Recommendation Report for Planning Permission for Works or Extension to a Dwelling

REF NO: BR/324/19/HH

LOCATION: Breeze
Belmont Street
Bognor Regis
PO21 1LE

PROPOSAL: Single storey front and side extension. (This application may affect the setting of a Listed Building)

PROPOSED GROUND FLOOR PLAN

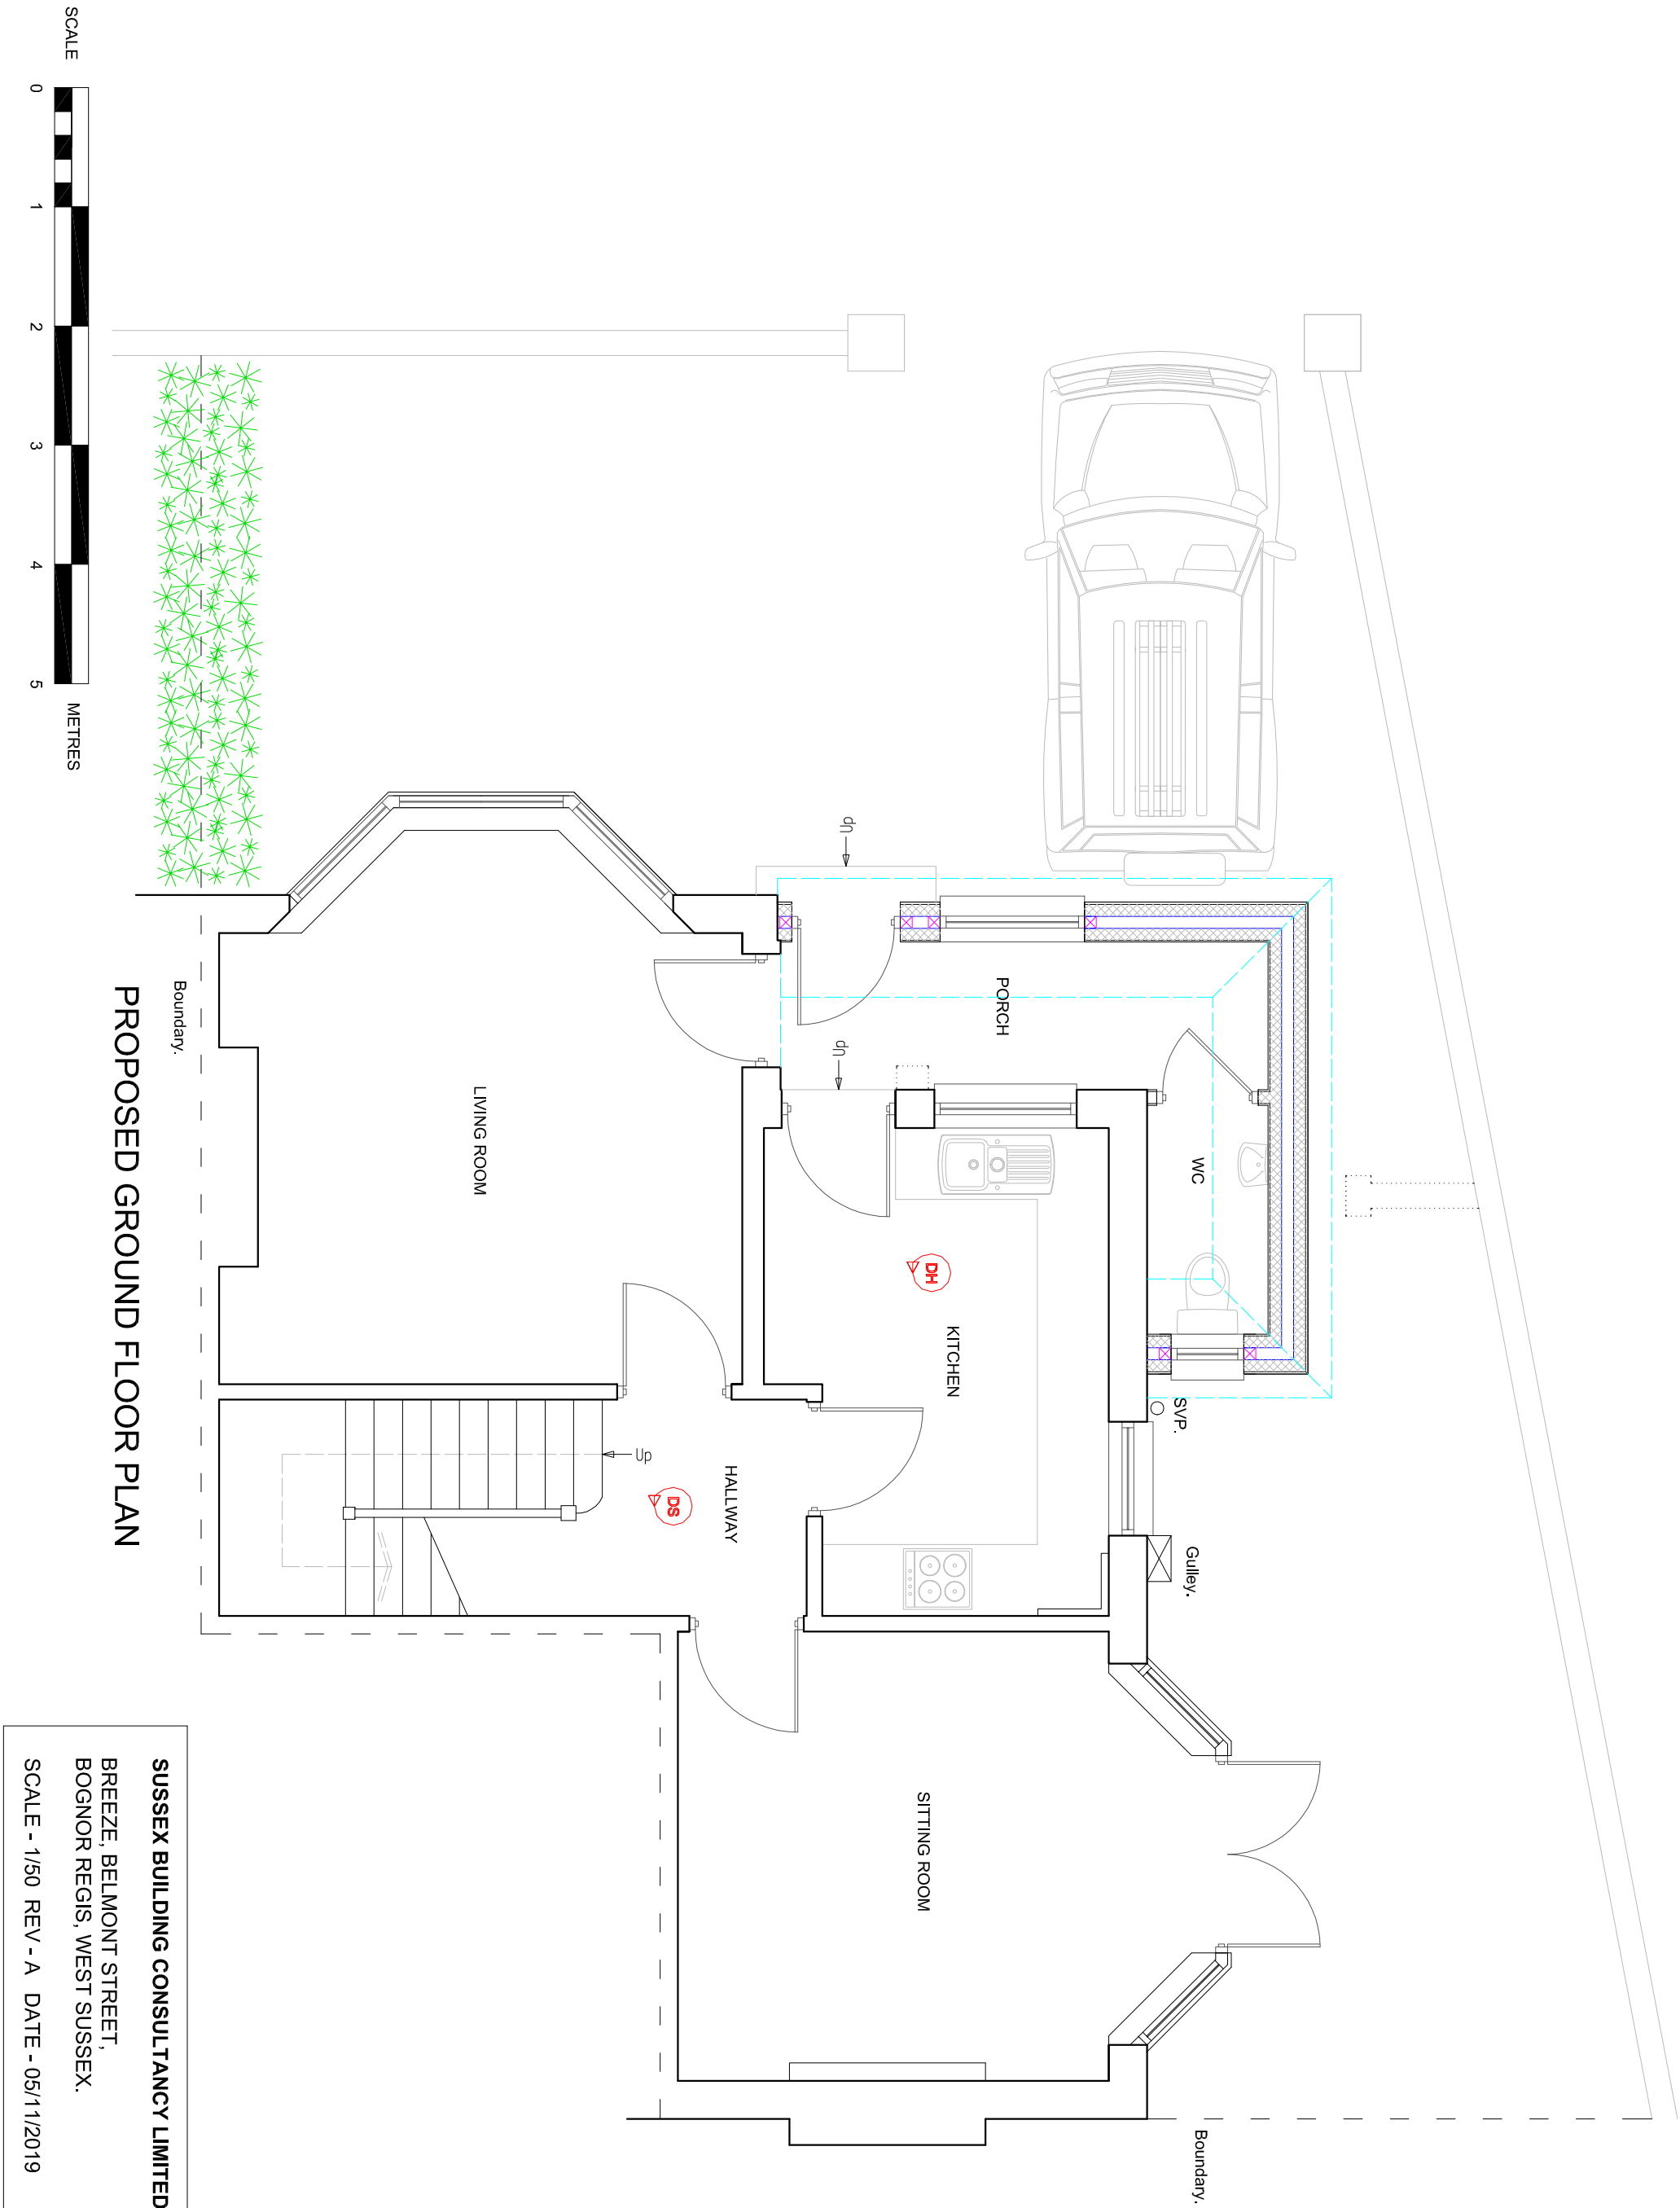
The addition will be situated to the south west of the dwelling and with the property located to a corner, the development will be highly visible. There is an existing porch and this will be replaced with an extension forming an L shape wrapping around to the side elevation. Due to an existing side addition, the extension is only partially visible from the rear. The extension will have a depth of 1.5m. The development is modest in scale and appear subservient to the host dwelling.

The surrounding properties are varied in style and design and as such the proposal is not considered to result in the dwelling appearing out of character with the area. The materials proposed will match that of the host dwelling which ensures it will appear well integrated. As the extension wraps around the dwelling, it retains between 0.9m and 1.6m to the western boundary.

The extension has a depth of 1.5m and a width of 4.5m along the front elevation where it then wraps around the side extending a further 2.5m towards the rear. The extension will have eaves to a height of 2.5m with a hipped roof to a maximum 3.5m. There will be an additional window to the southern elevation which will overlook the street scene.

PROPOSED ELEVATIONS

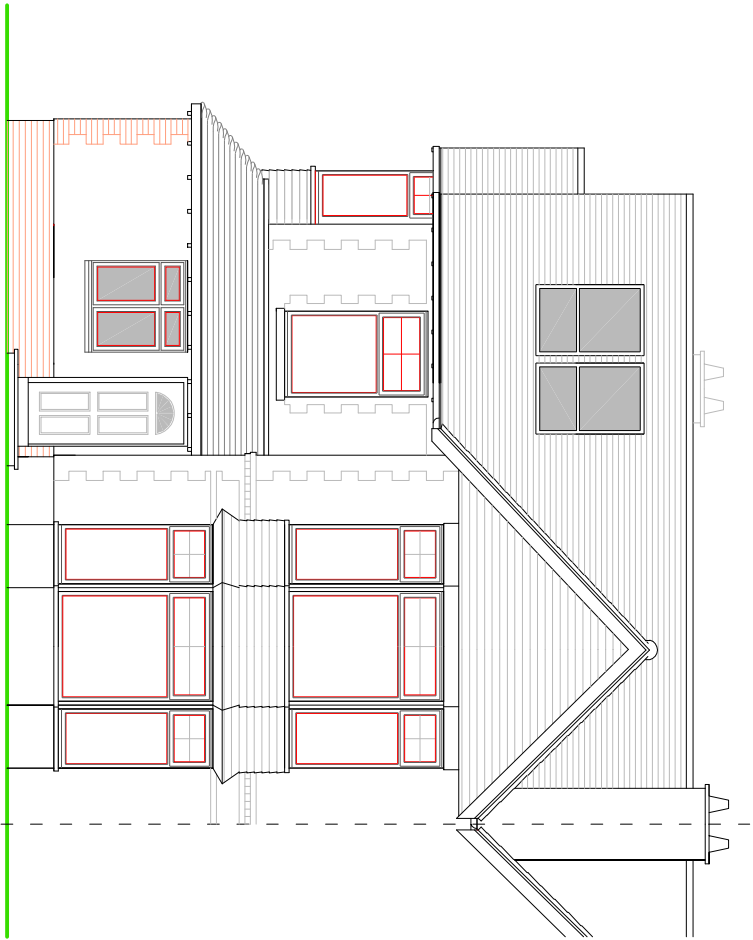
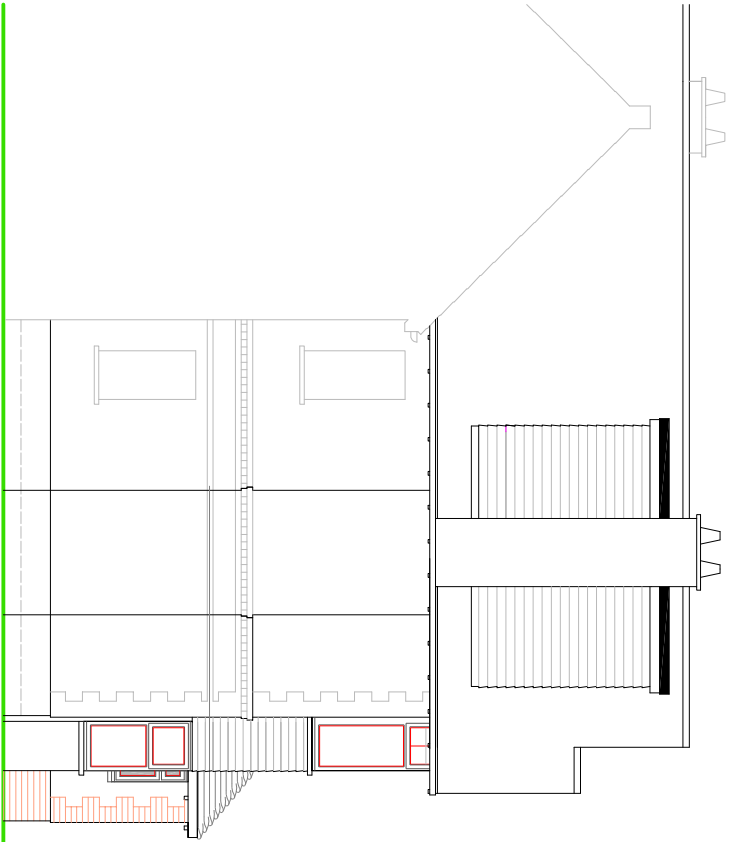
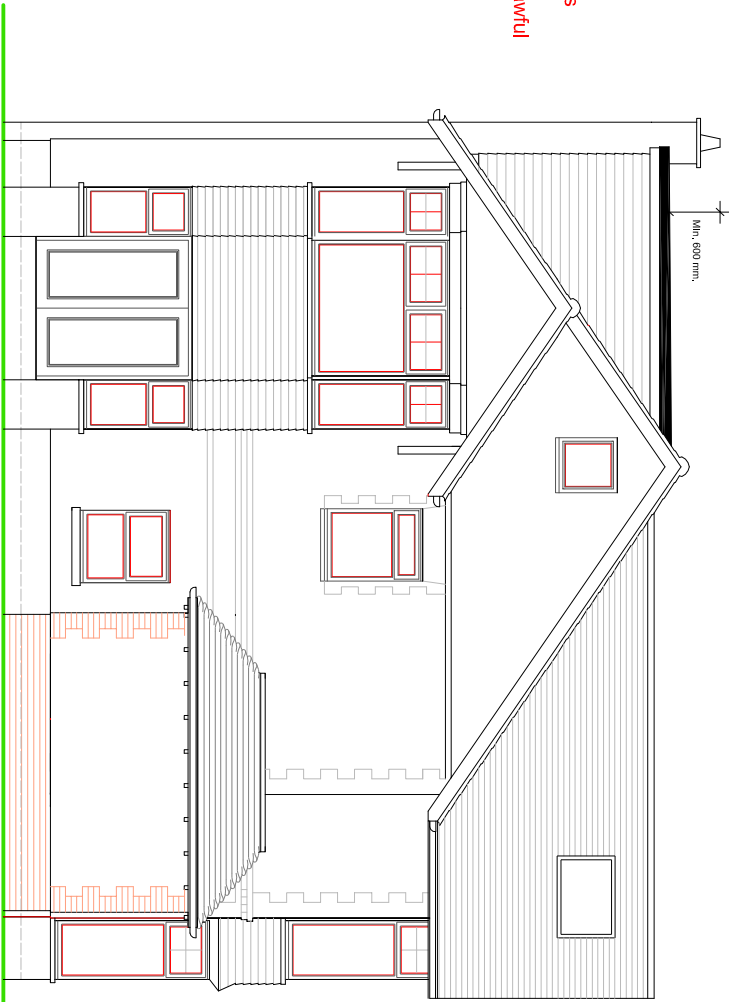
With the property located to a corner and the extension to the south western side, the development is not considered to give rise to adverse impacts upon neighbouring amenity by way of overbearing, overshadowing or overlooking and accord with D DM1 and D DM4 of the Arun Local Plan.
